DECISION DELEGATED TO HEAD OF PLANNING

Application No: H09-0909-25 **Applicant:** Midwest Polychem

Proposal: Outdoor storage of materials, additional building & structures & external generators - Retrospective

Location: Laurel Lodge Farm Hurn Road Holbeach Hurn

EXISTING FLOOR PLAN

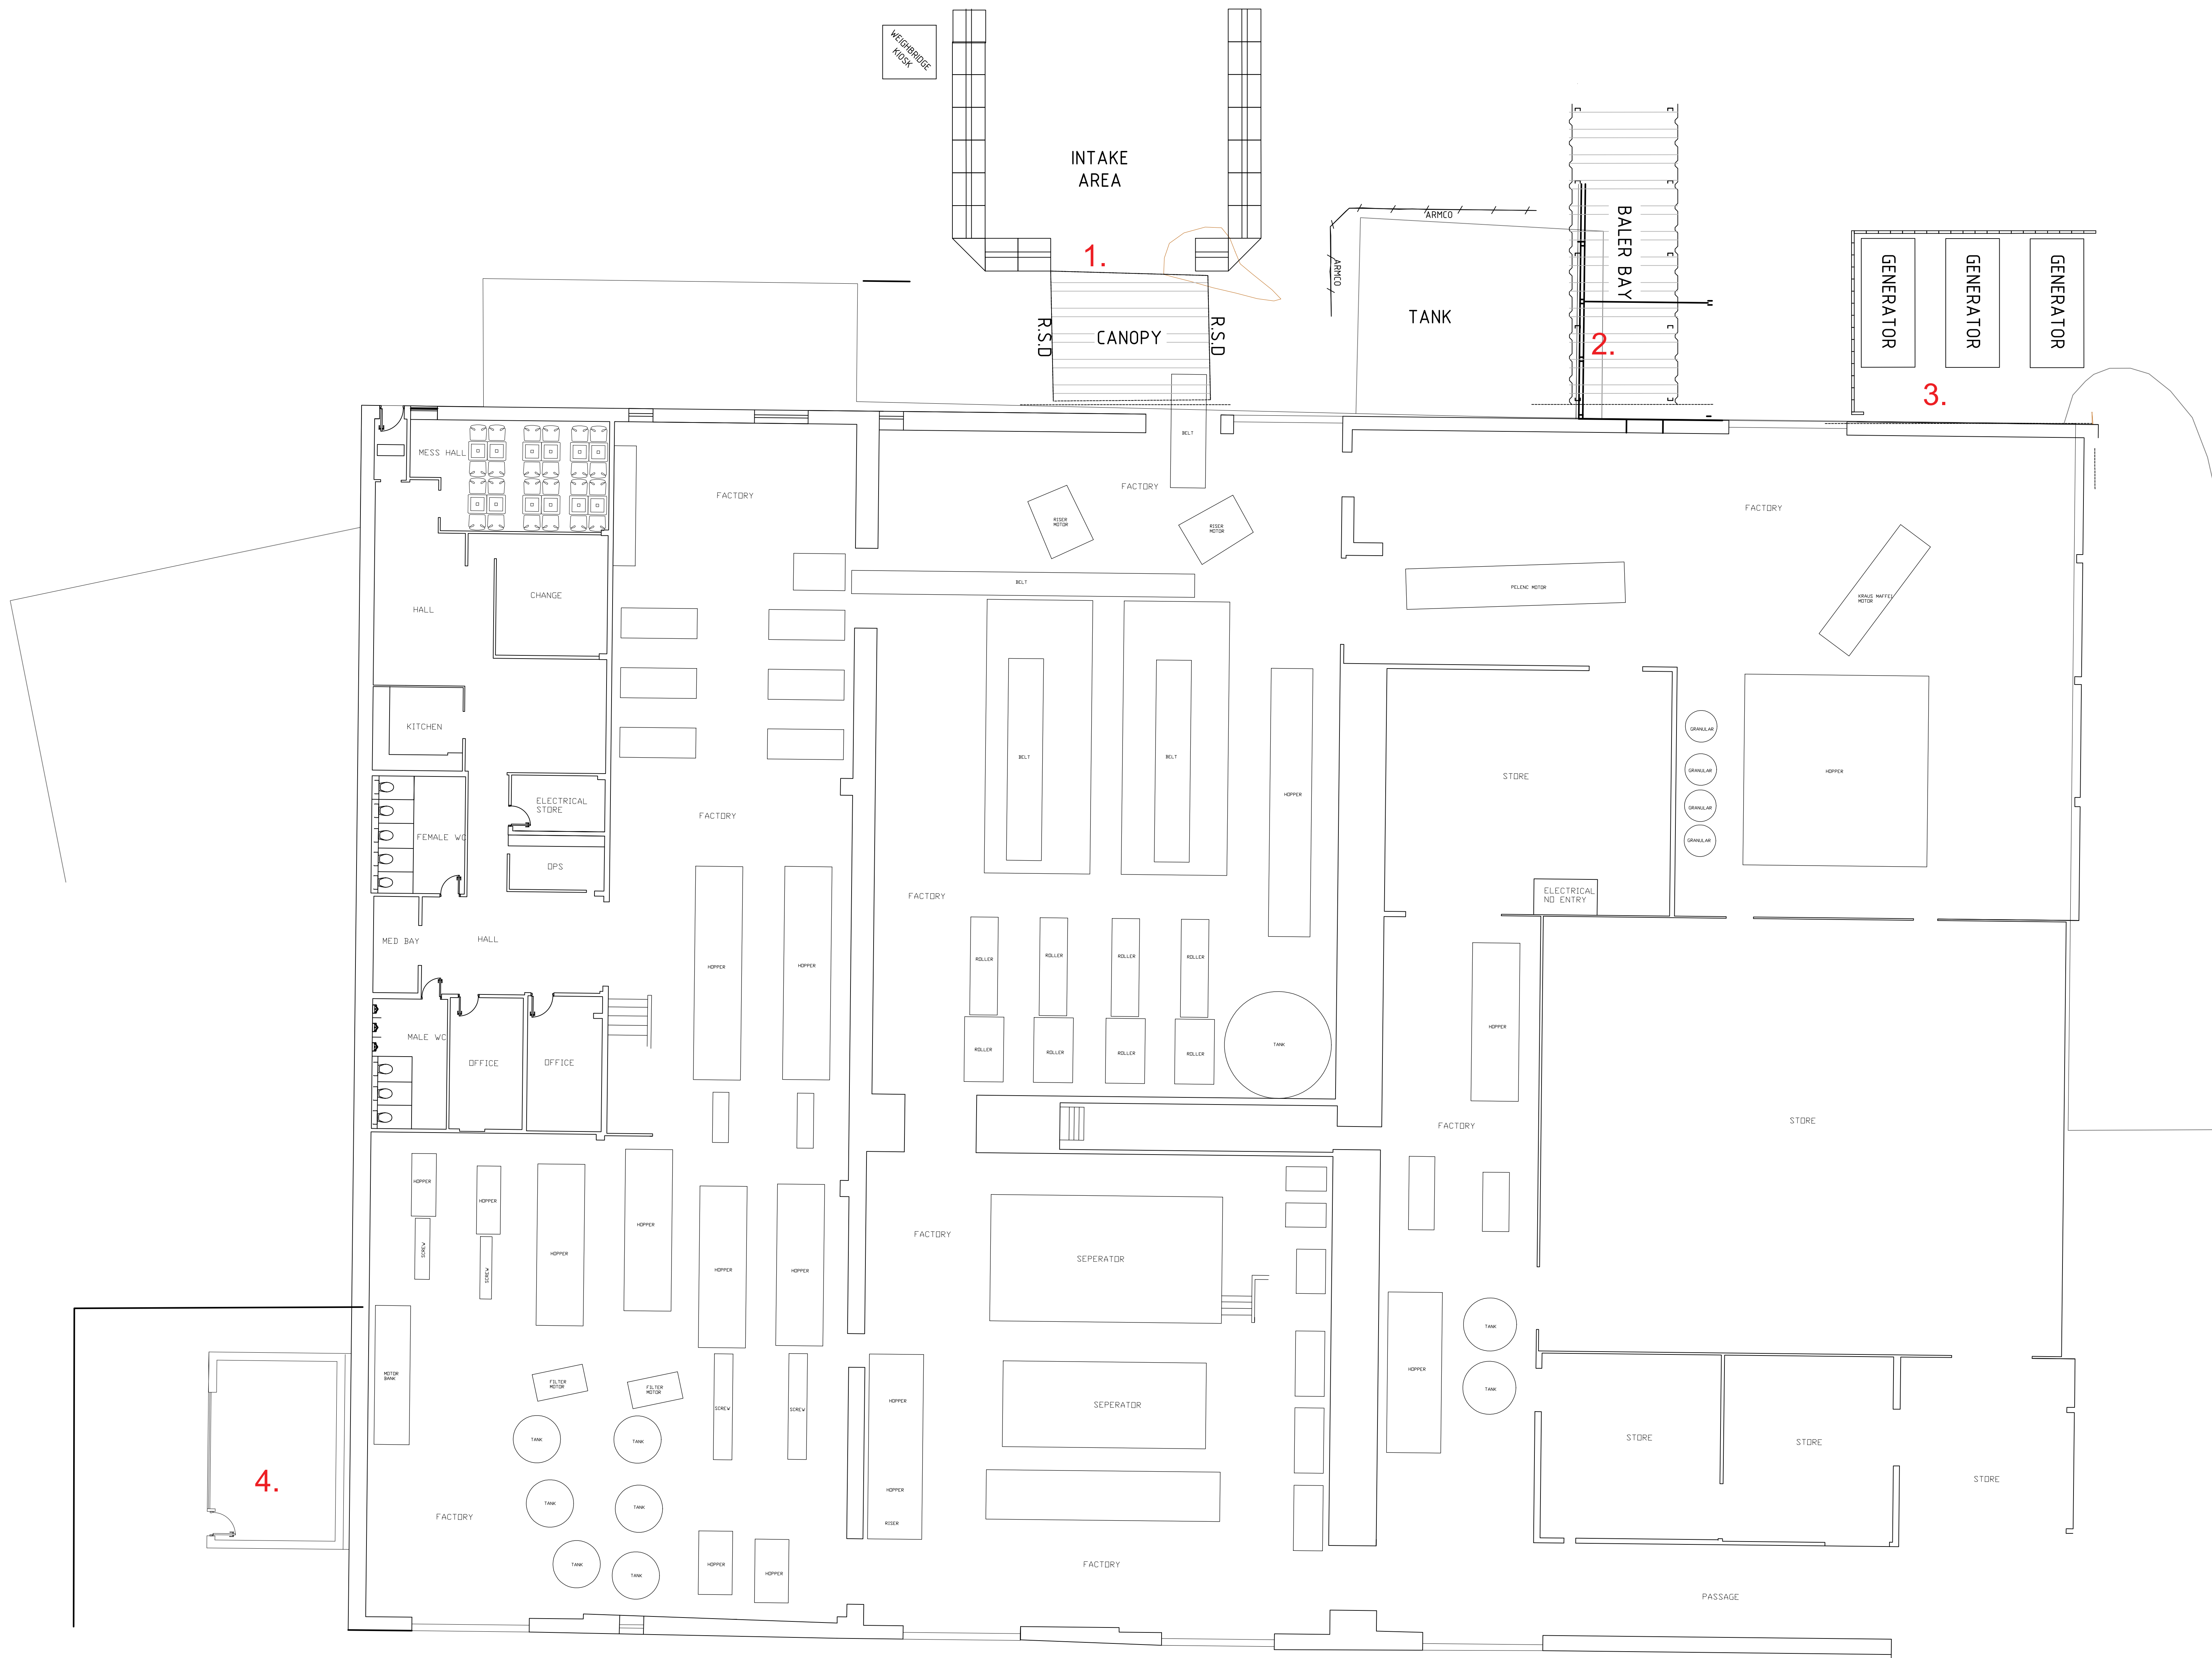
The steam boiler extension appears to be proportionate to the existing building, however, the submitted plans lack detail as the proposed materials and doorway details are not shown. This remains unchanged from the previous submission.

The nearest dwellings to the site are located within Laurel Lodge. It is unclear if the proposed steam boiler room will include plant and if so what the noise level of this plant could be. This should be clarified with the applicant prior to determination to ensure the noise levels would not be unacceptable.
